Local Policing Support Team

Our Ref: LM/ARU/20/25A

Date 2nd September 2020

RE: Land to the south of Ford Lane and East of North End Road Yapton BN18 0DS

Detailed Play Provision - LEAP

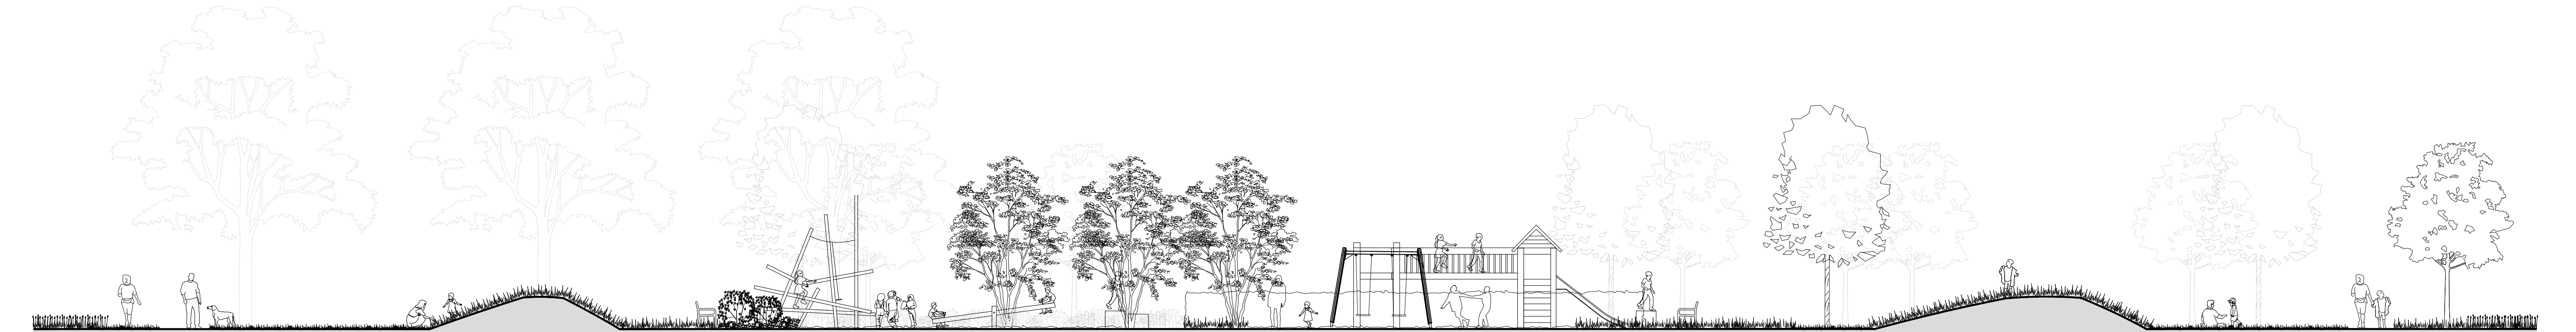
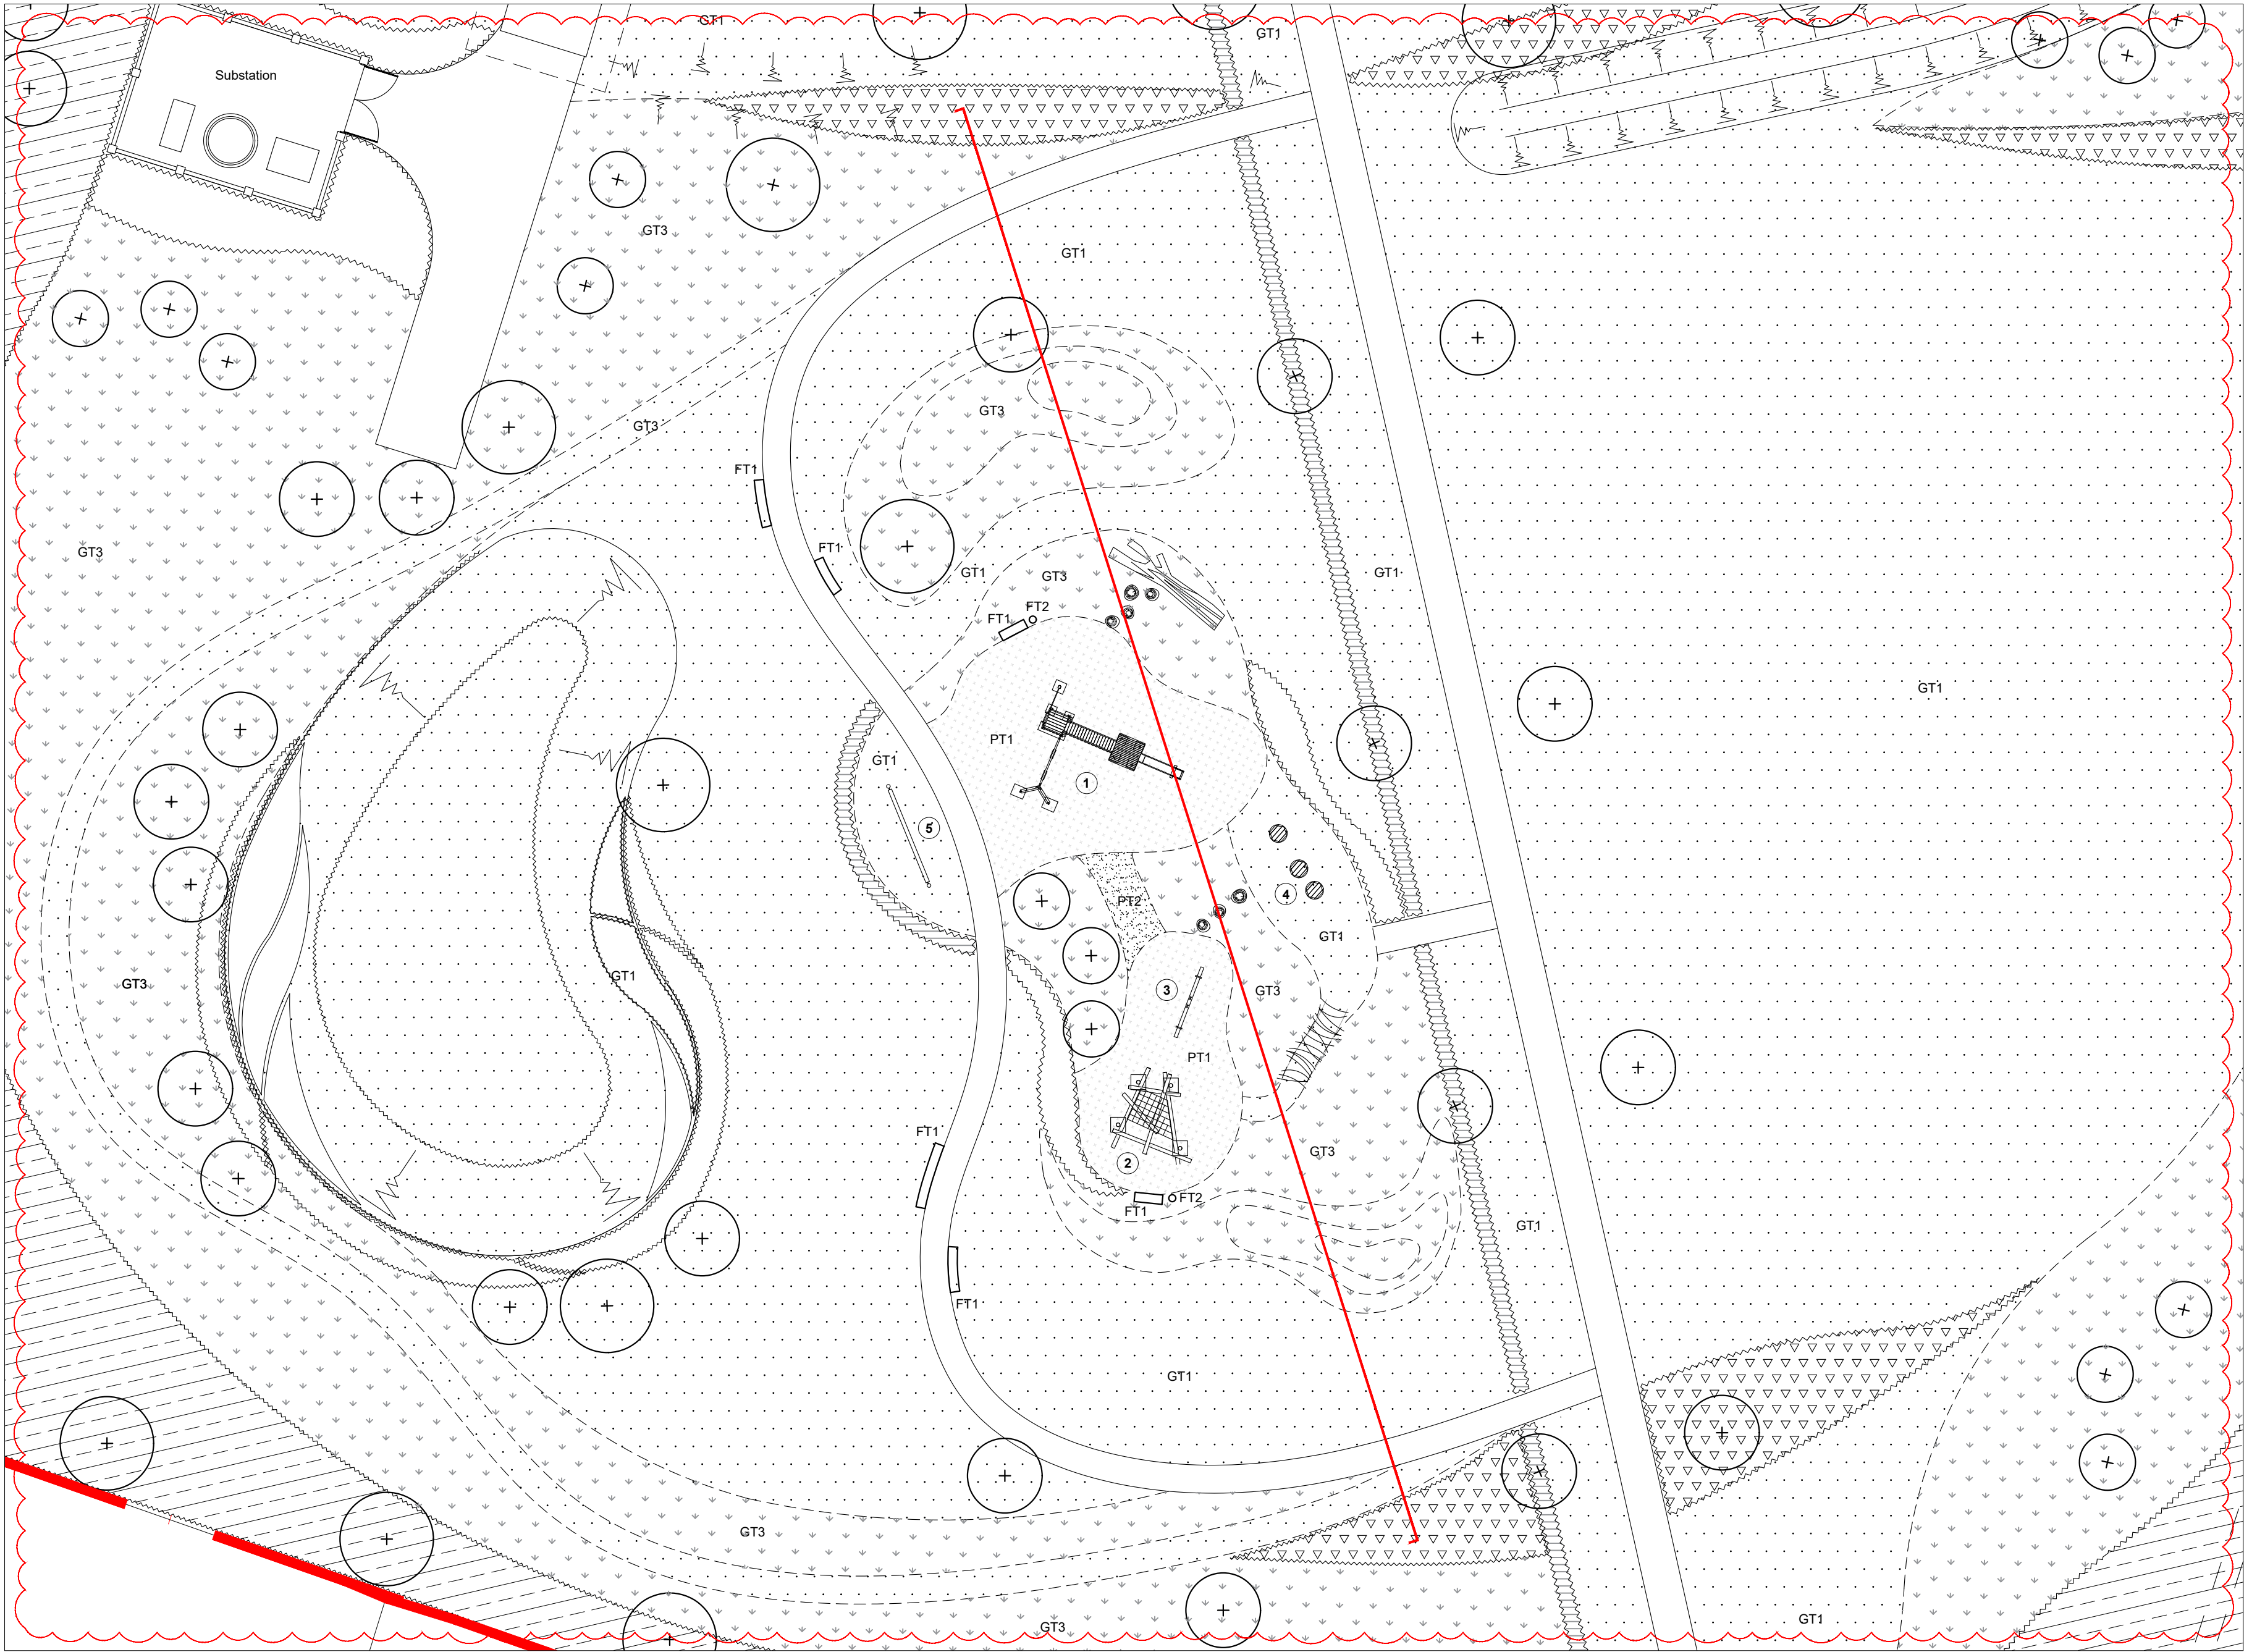
With regards to the LAP - areas of play should be situated in an environment that is stimulating and safe for all children, be overlooked with good natural surveillance to ensure the safety of users and the protection of equipment, which can be vulnerable to misuse. They should be designed to allow natural surveillance from nearby dwellings with safe and accessible routes for users to come and go. Boundaries between public and private space should be clearly defined and open spaces must have features which prevent unauthorised vehicular access. I would ask that when consideration is given to the eventual location that it is surrounded with railings with self-closing gates to provide a dog free environment.
